Please ask for: Nicola Moore
Email: nicola.moore@arun.gov.uk
Telephone: Ext 37944
Our Ref: WA/106/21/CLP
Your Ref:
Date: 9th November 2021

Lawful Development Certificate for a Proposed Use or Development

Development: Lawful development certificate for a proposed half acre extension to the south wall of existing greenhouse.
Location: Crosslands Nursery Barnham Lane Walberton BN18 0AX

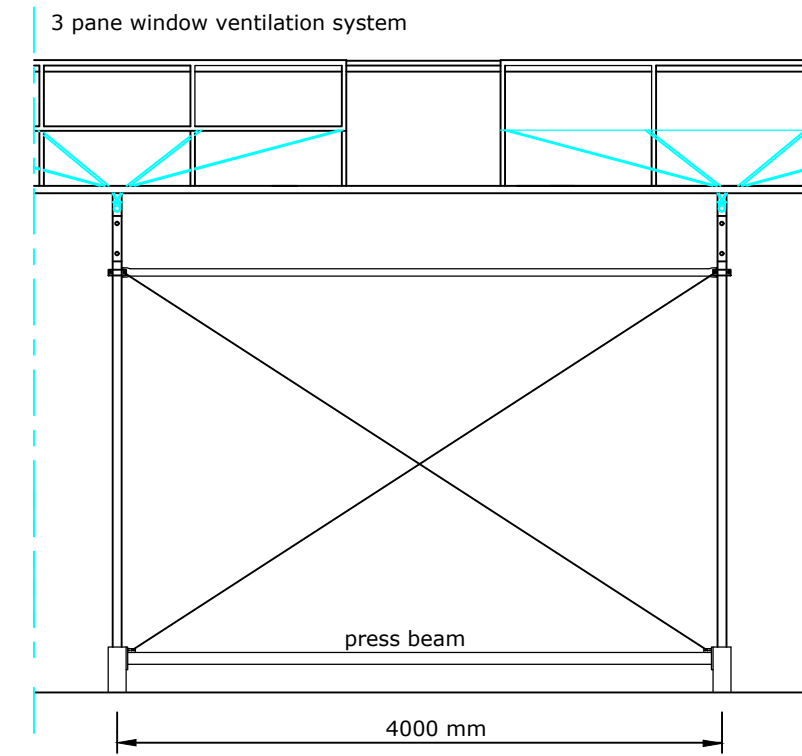
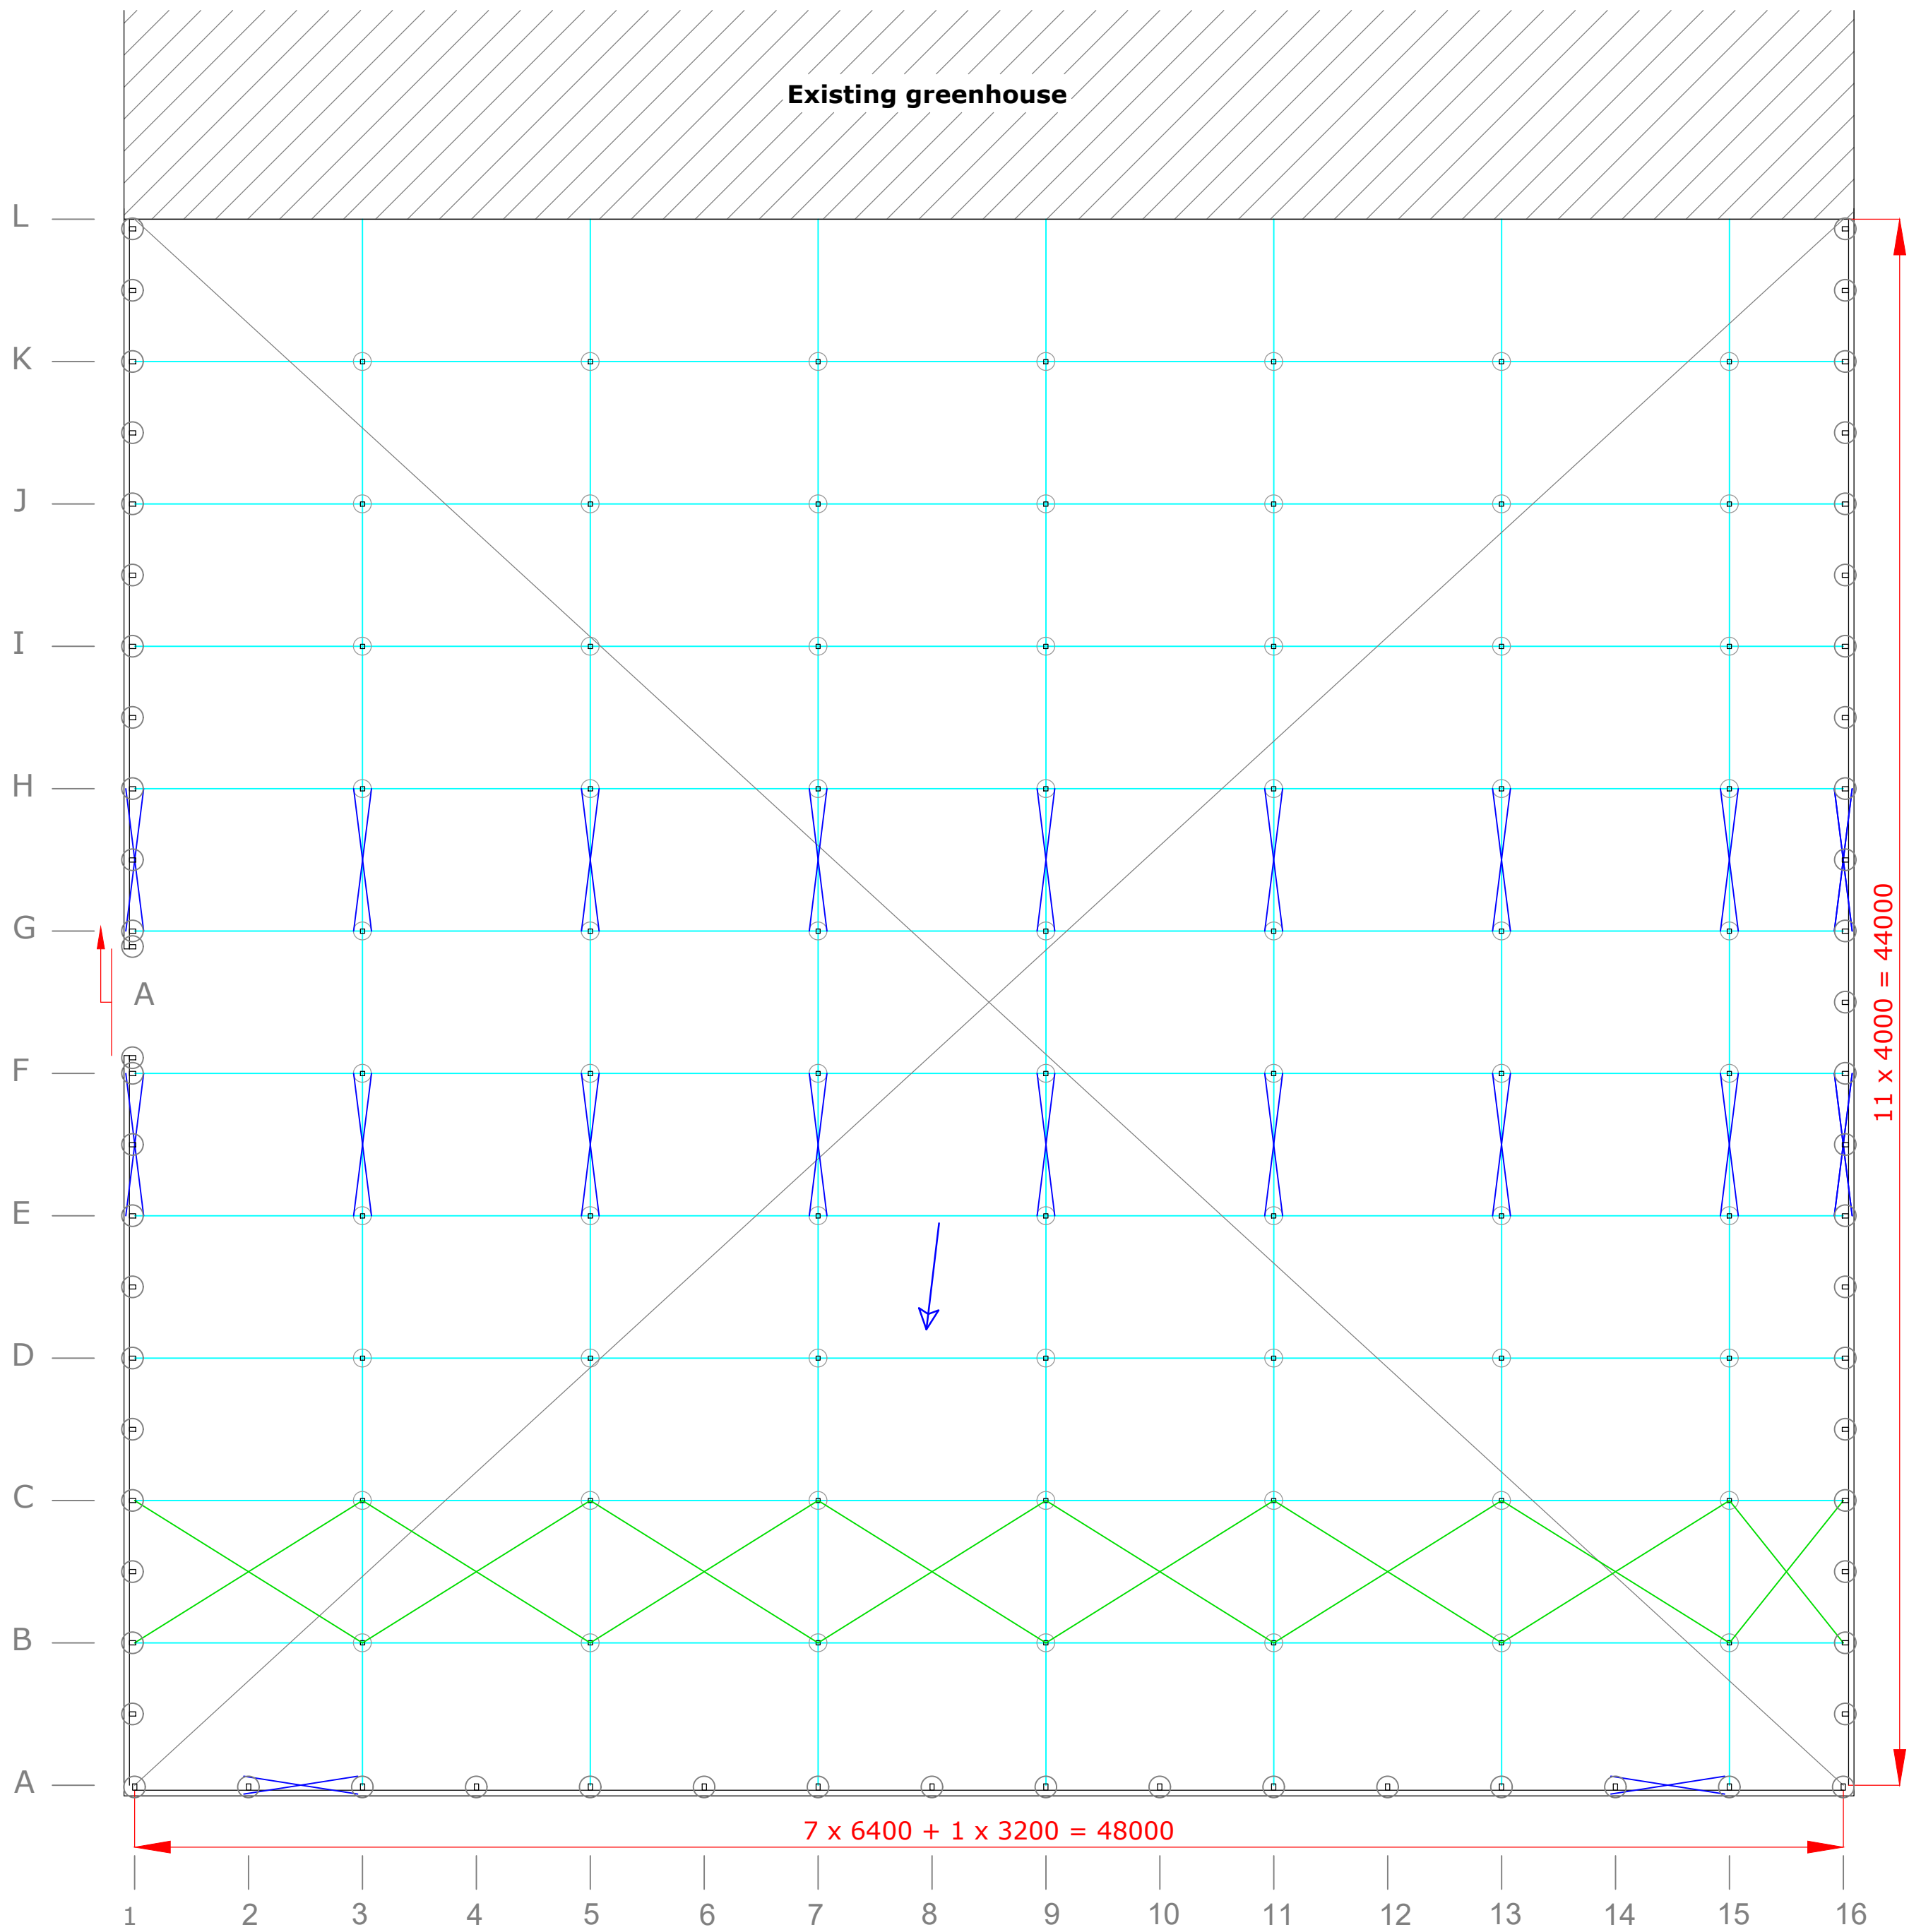
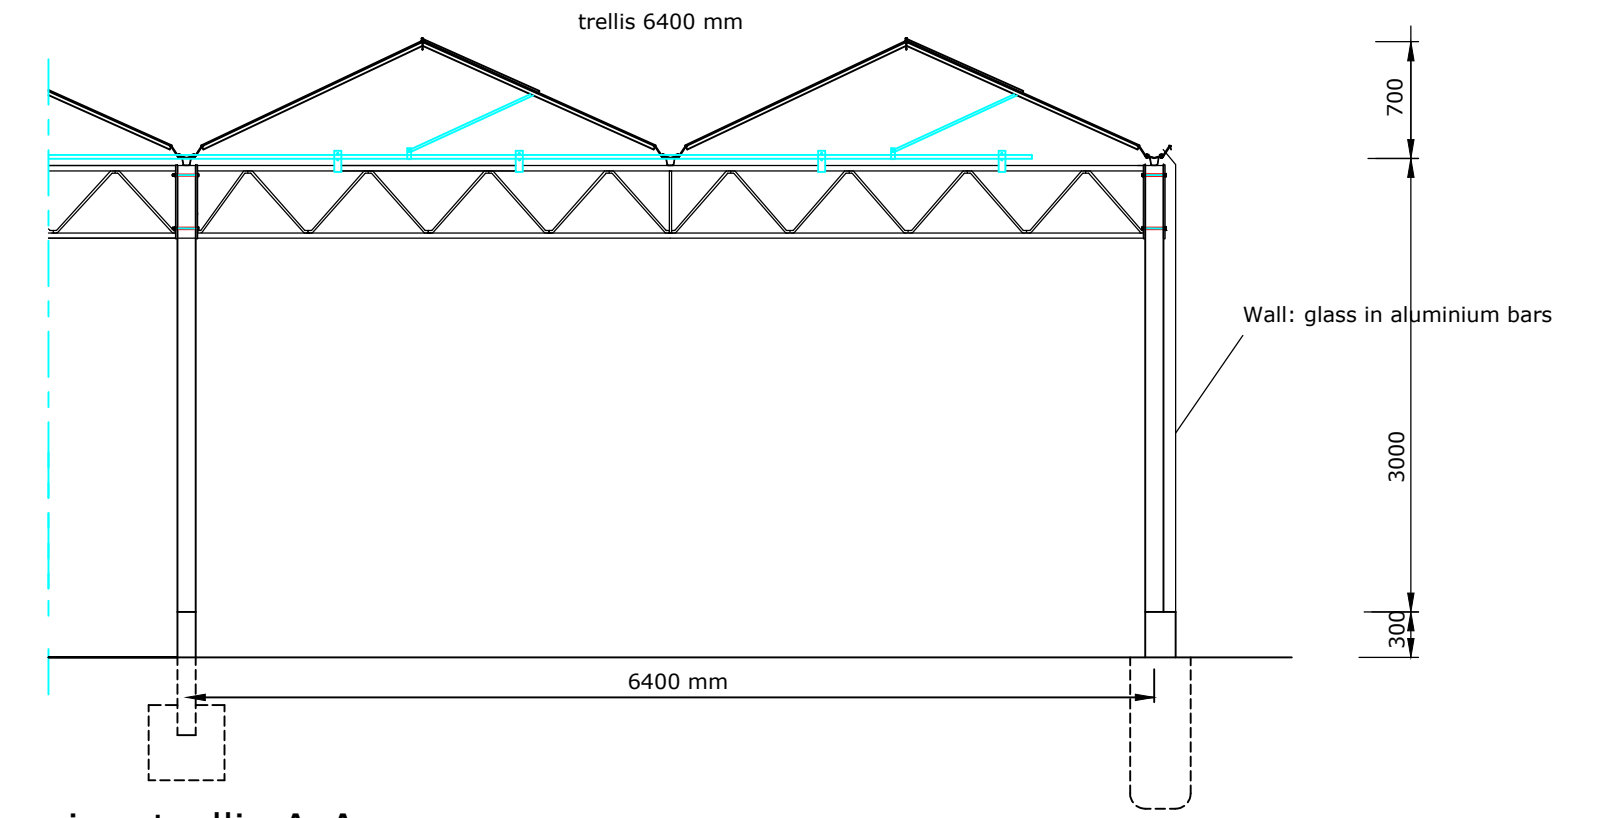
The submitted floor plans and elevations do not scale correctly, please re submit at a scale of 1:100 or 1:50. The plans should be clearly labelled existing and proposed.
